Our Ref: CM/20/15/PL

**Town & Country Planning Act 1990 (as amended)
Town and Country Planning (Development Management Procedure) (England) Order 2015
Application for Planning Permission**

Development 1 No storage barn and earth bund
Location Northwood Farm Yapton Road Climping

cn8015/r

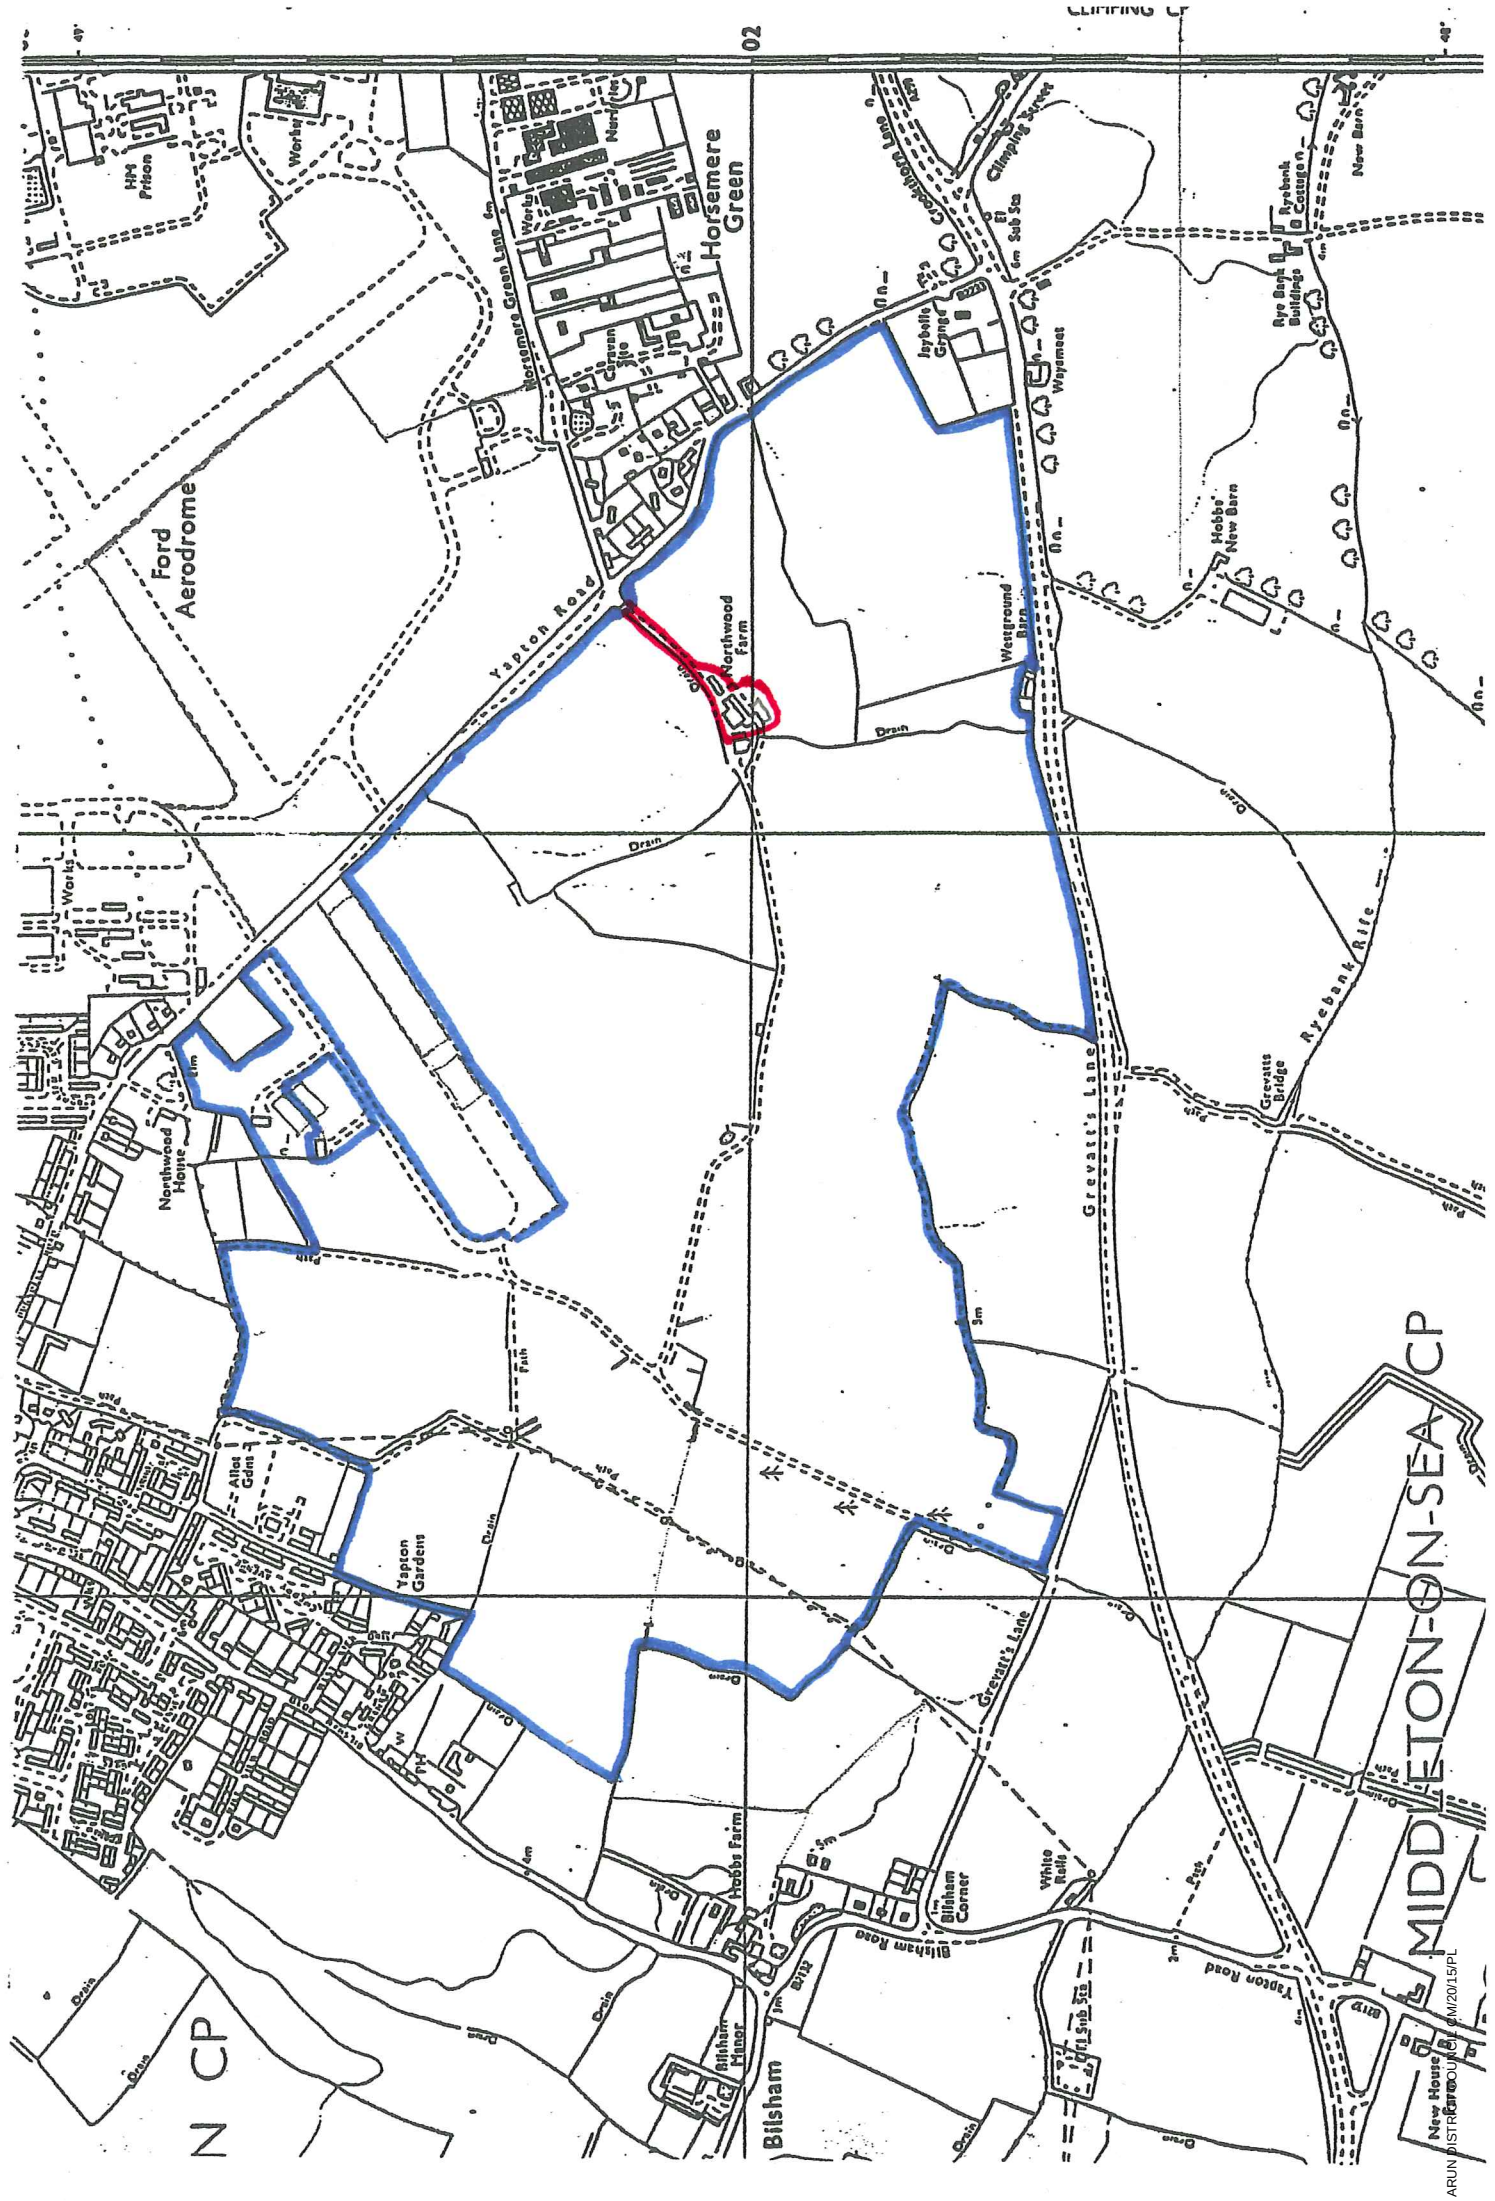
Location Plan

Please submit 1 electronic or 3 paper copies of an amended Location plan at a scale of 1:1250 or 1:2500 for rural areas with the red edge amended to include all of the proposals within it. Further details of what must be included on the plan can be found in the National Validation Requirements.
